1 December 2021

## **SECTION 4.55(1A) MODIFICATION APPLICATION - SSD-10375 PITT STREET NORTH OVER STATION DEVELOPMENT**

This section 4.55(1A) Modification Application has been prepared on behalf of Pitt Street Developer North Pty Ltd (**the Applicant**) to amend SSD-10375 which applies to the Pitt Street North Over Station Development Stage 2 (**PSN OSD**) at 252 Pitt Street, Sydney.

PITT STREET INTEGRATED
STATION DEVELOPMENT - OSN
SSDA
GENERAL ARRANGEMENT ELEVATION
EAST ELEVATION - CASTLEREAGH STREET

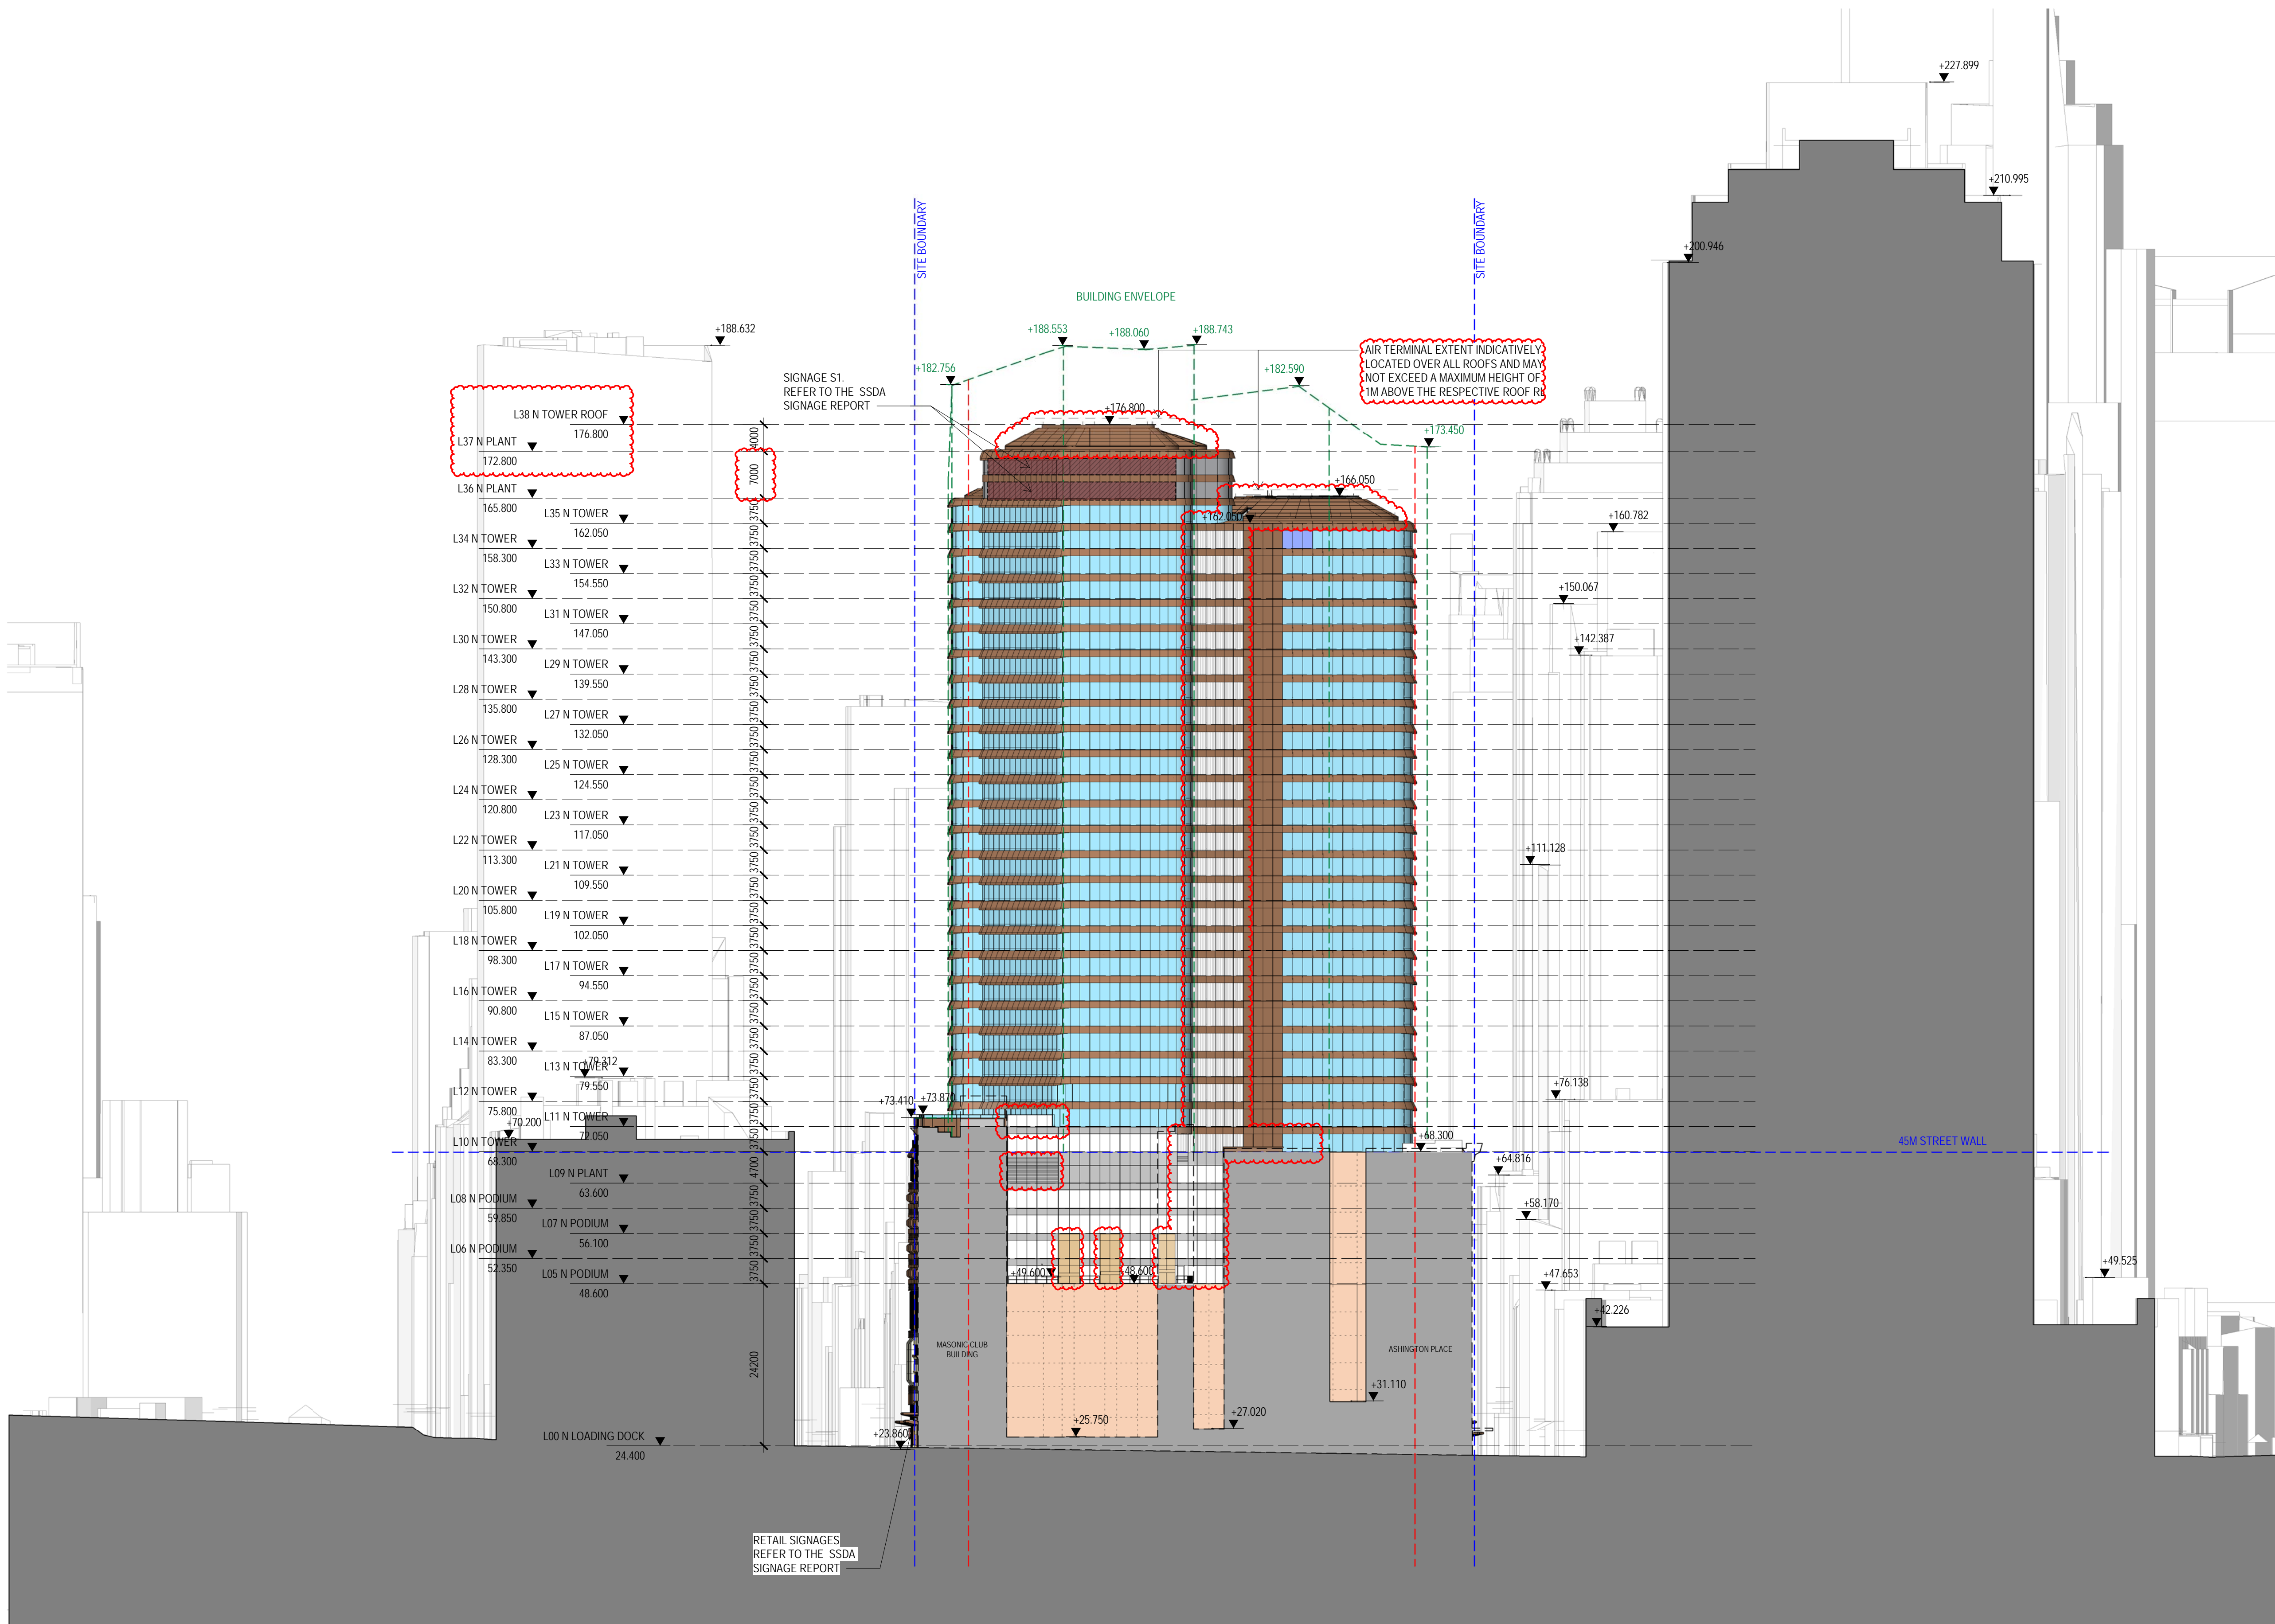
A correction has been made to the podium façade (level 5 through to level 9) on the eastern and western elevations to accurately show the corrugation detailing. This change is a graphical fix as illustrated in **Figure 7** and **Figure 8**.
